**WELWYN HATFIELD BOROUGH COUNCIL  
DIRECTORATE OF STRATEGY AND DEVELOPMENT**

**DELEGATED APPLICATION**

**Application No:** 6/2016/0159/FULL  
**Location:** The Galleria, Comet Way, Hatfield, AL10 0XR  
**Proposal:** Alterations to internal road junction near northern access by creation of roundabout together with installation of associated road signs  
**Officer:** Mr M Peacock

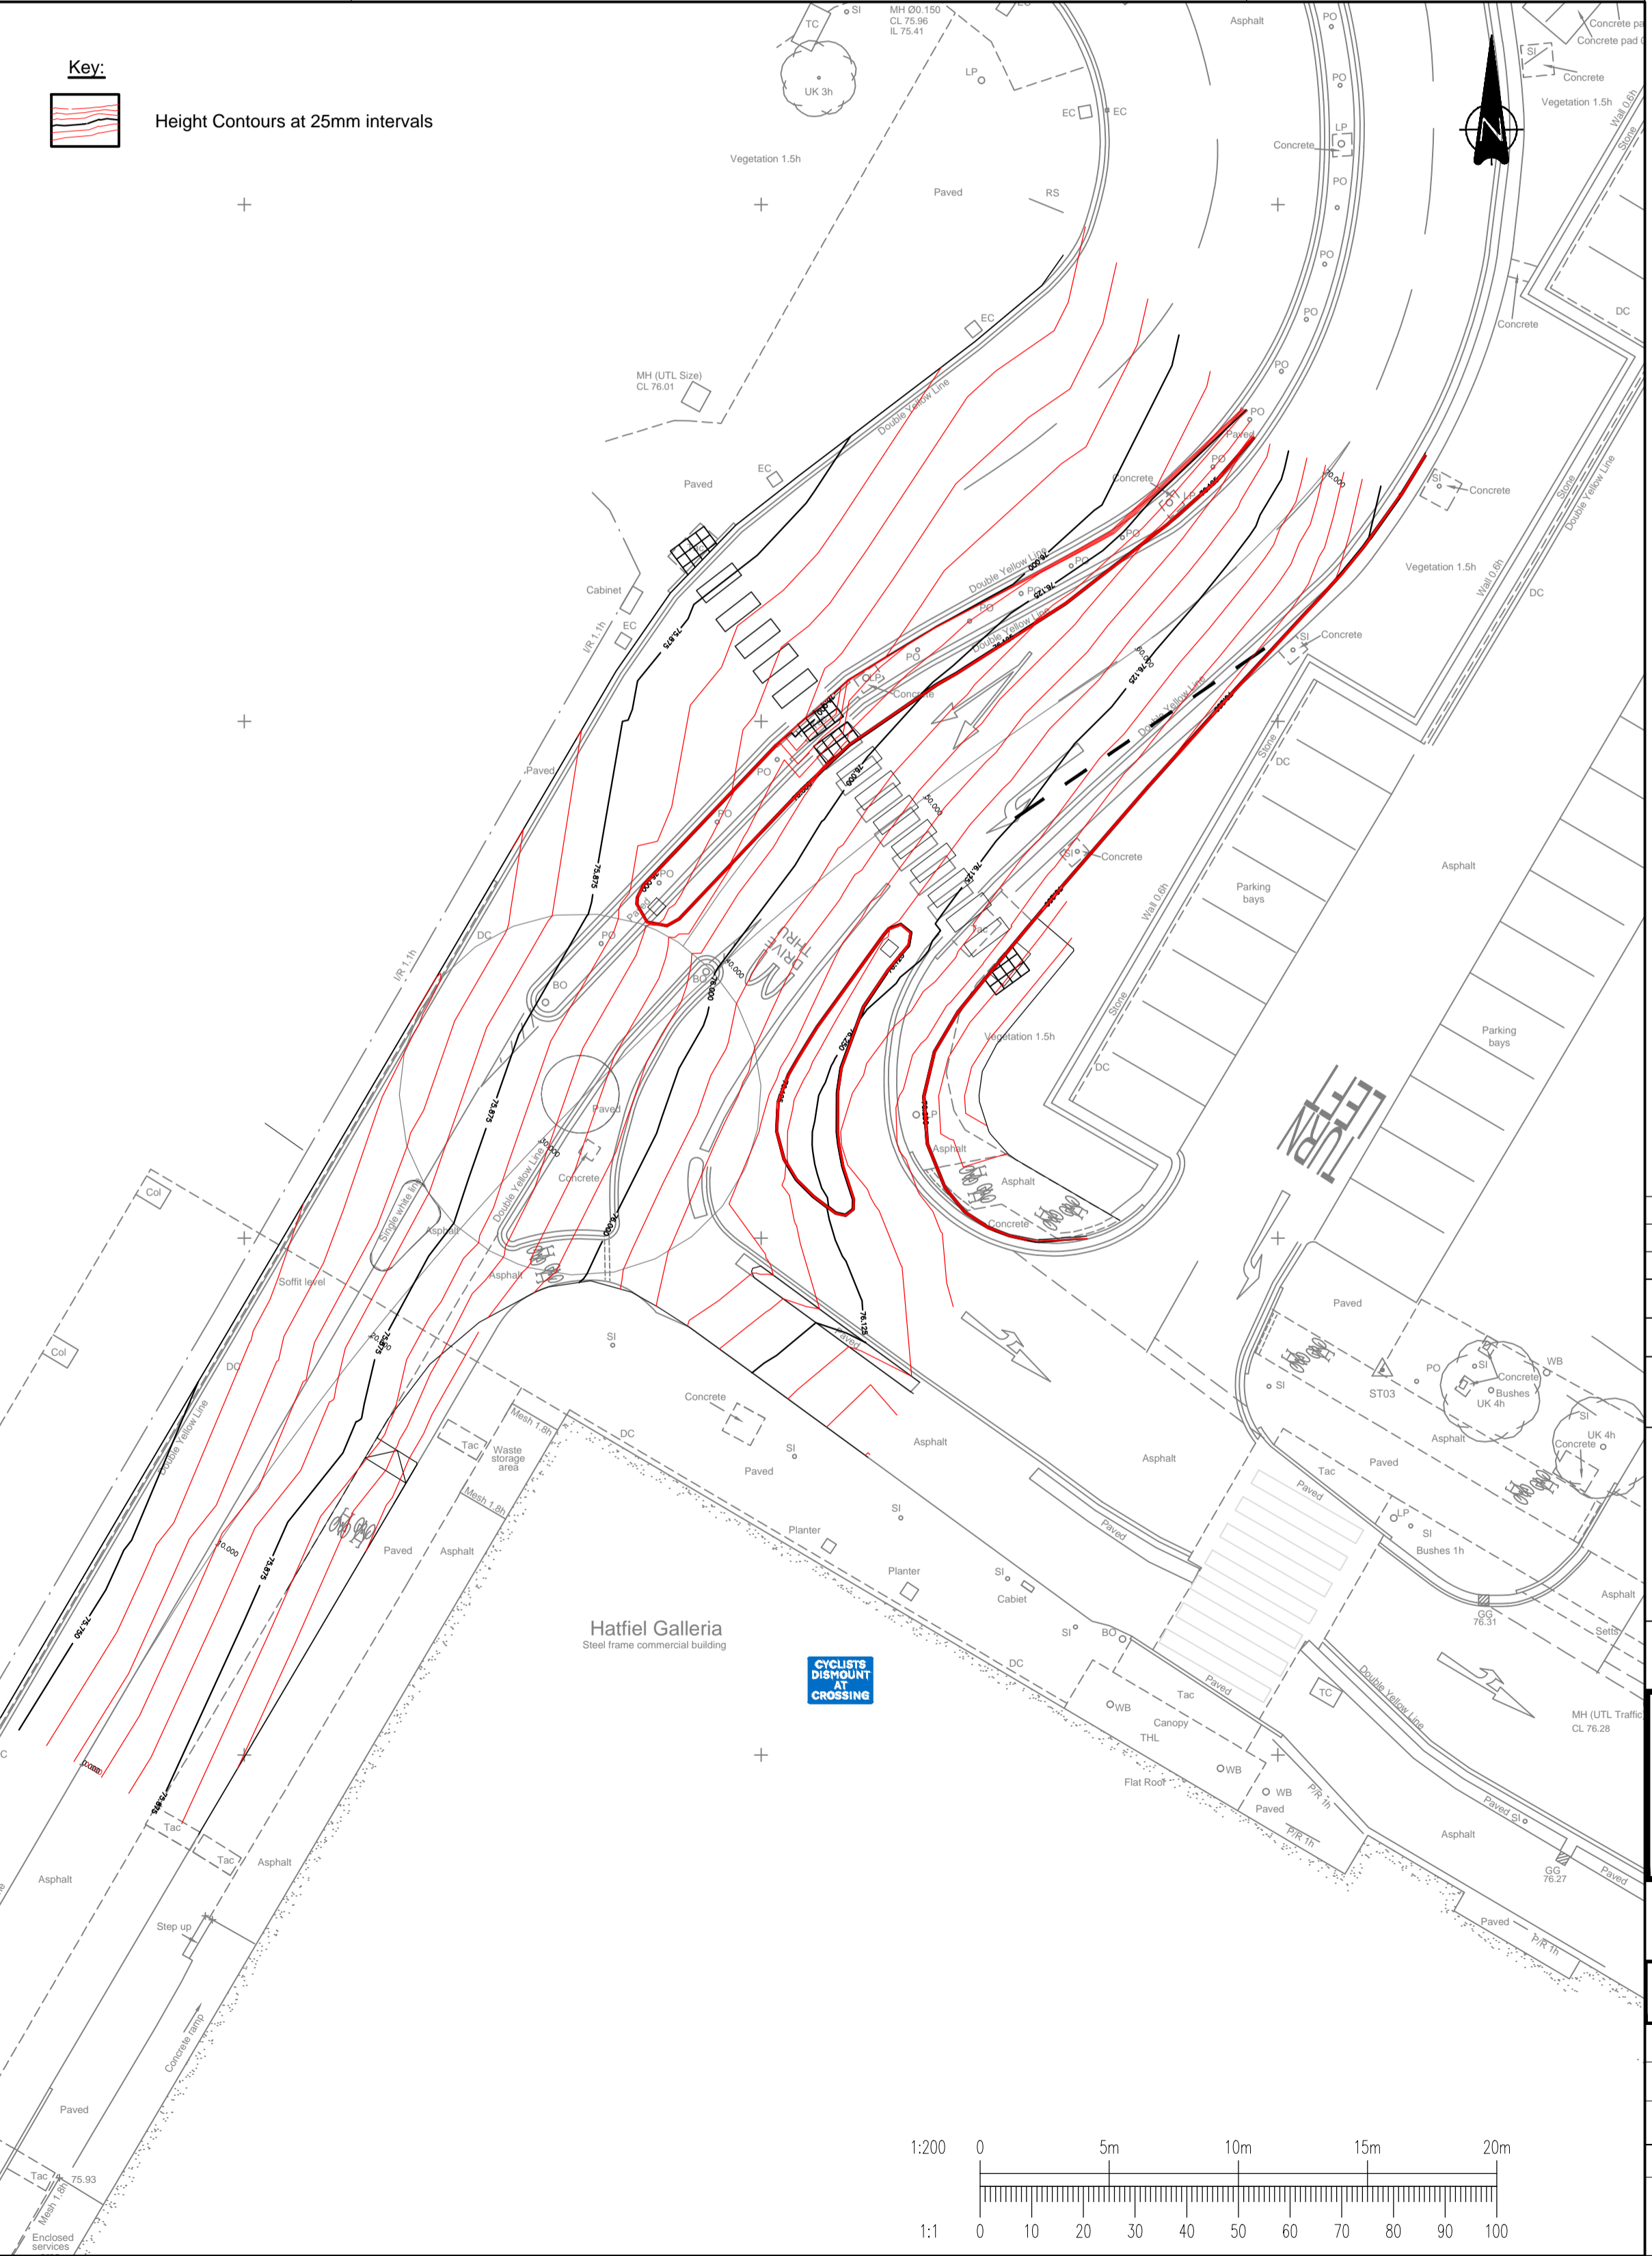
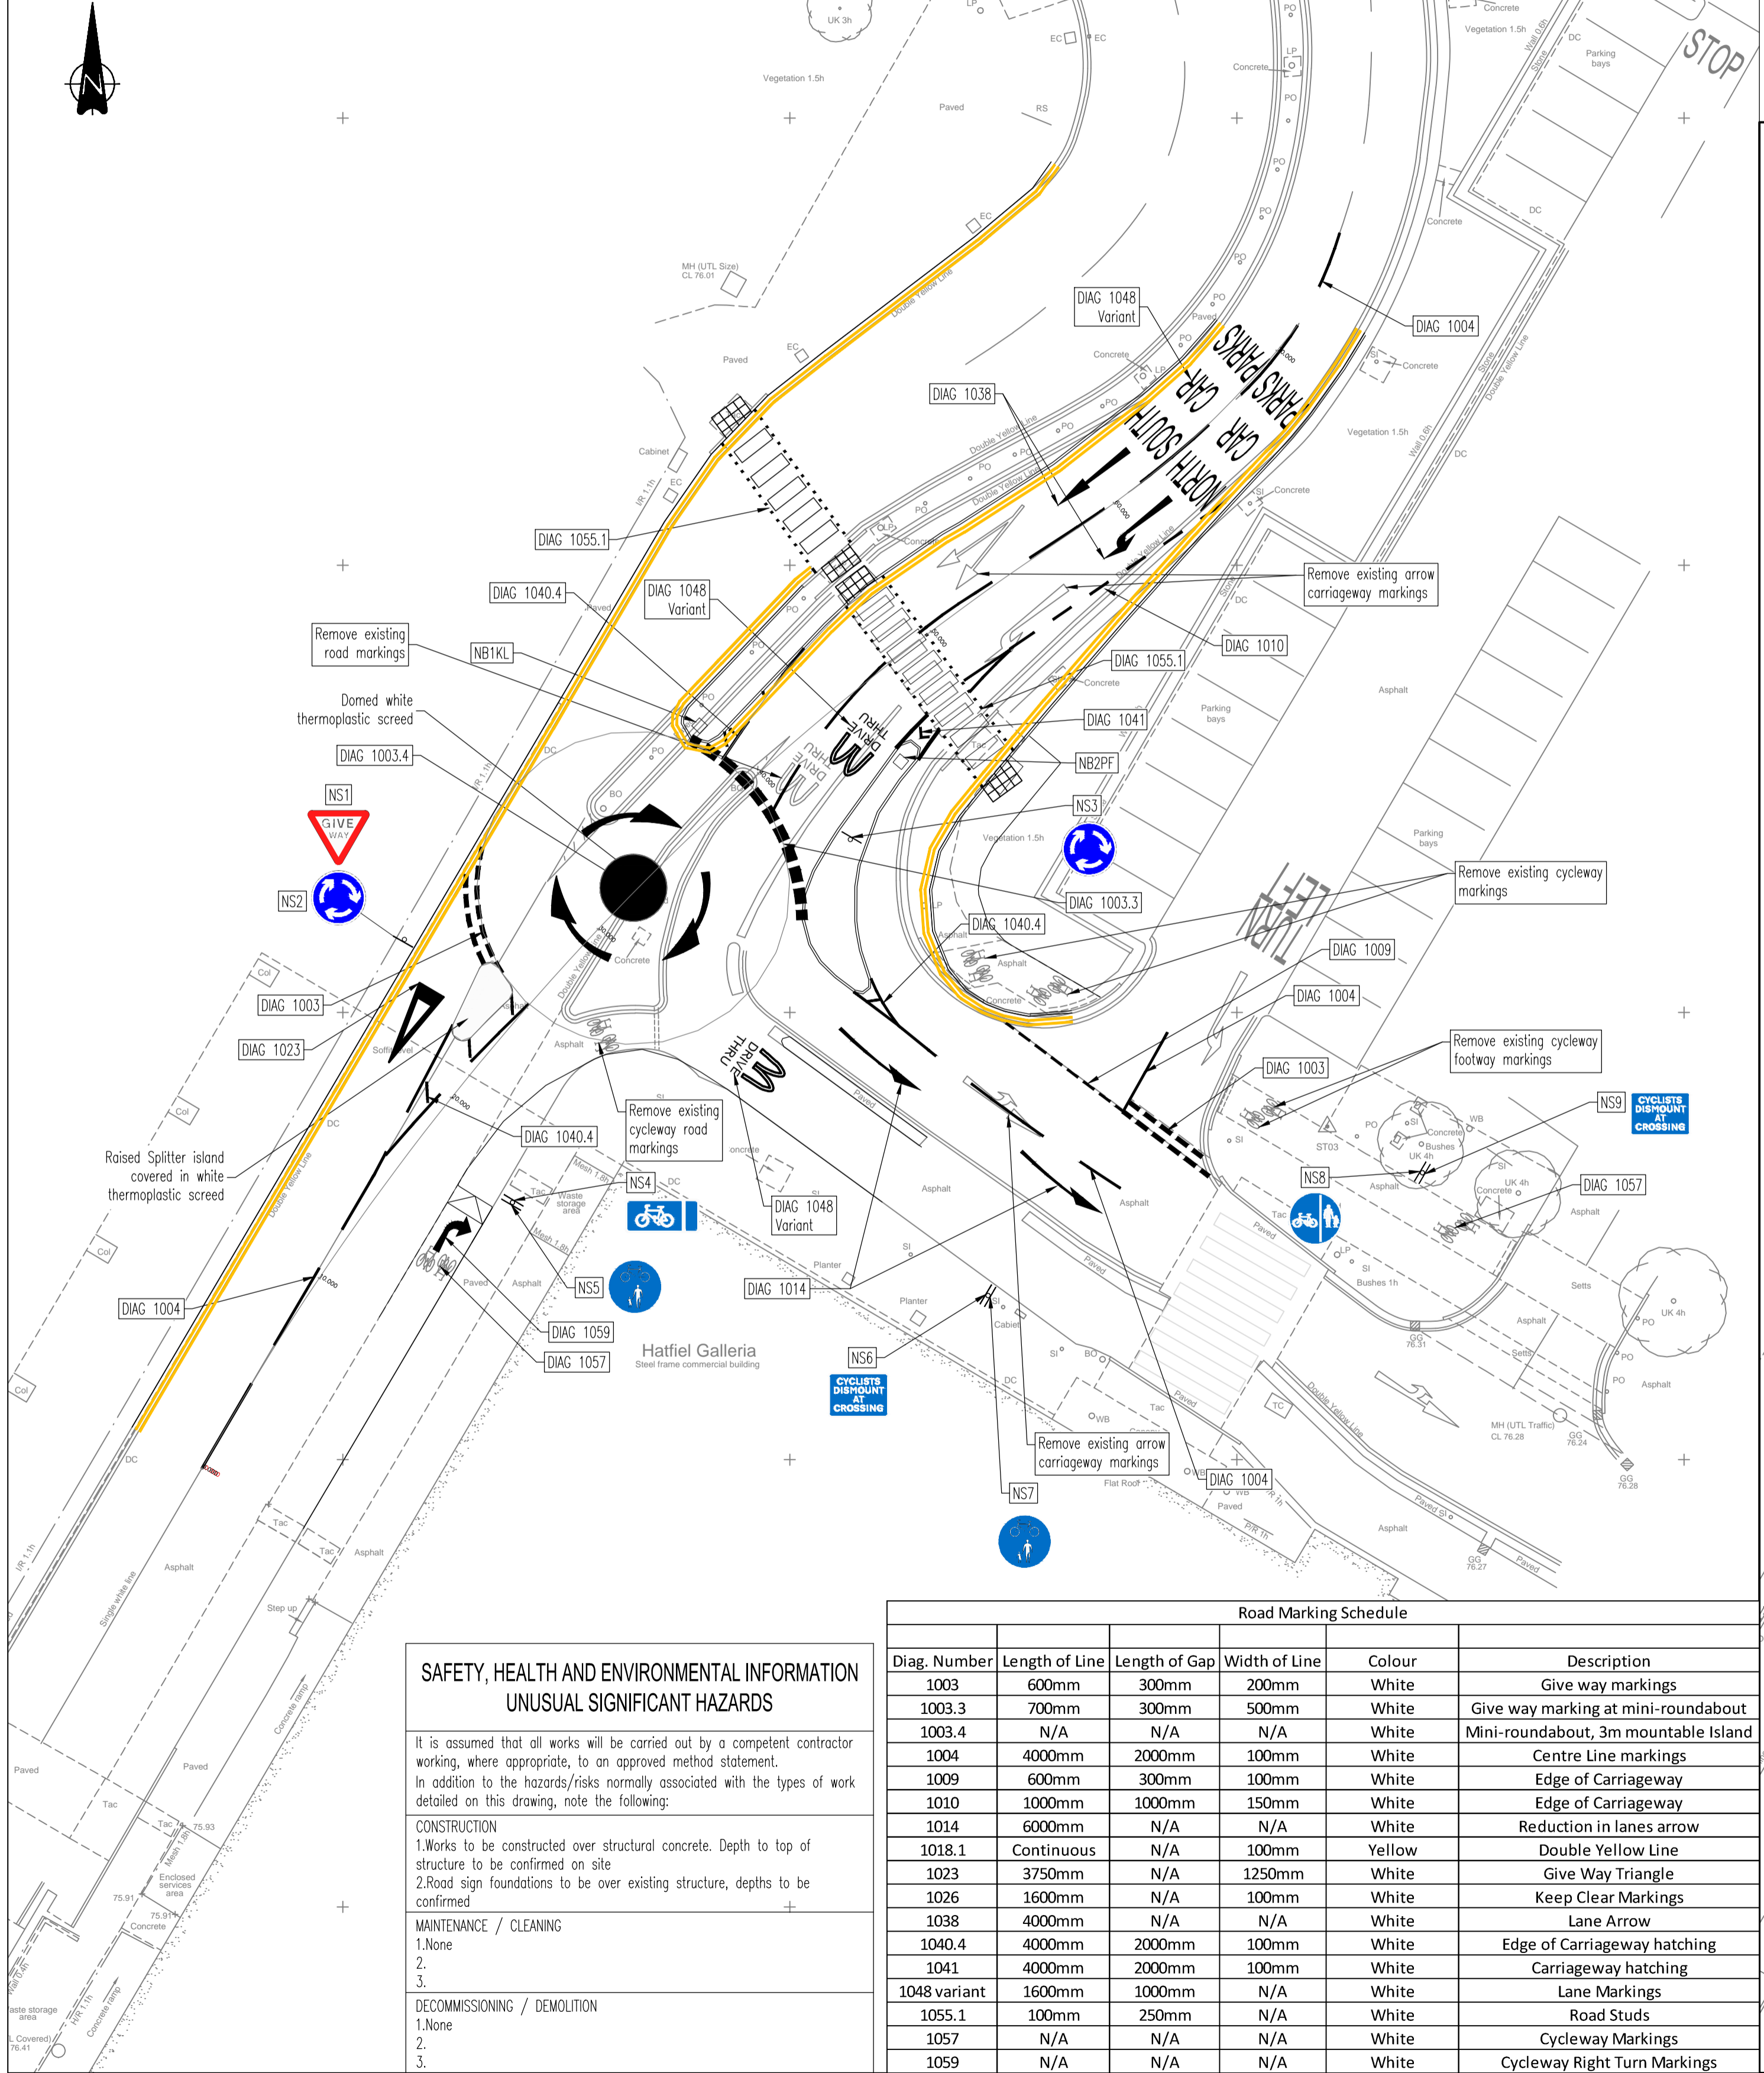
Vehicular tracking is undertaken within the supporting documentation and demonstrates that private cars are able to undertake the provided right turn movement and that the mini-roundabout does not interfere with vehicles entering from A1001 directing to the southern part of the site.
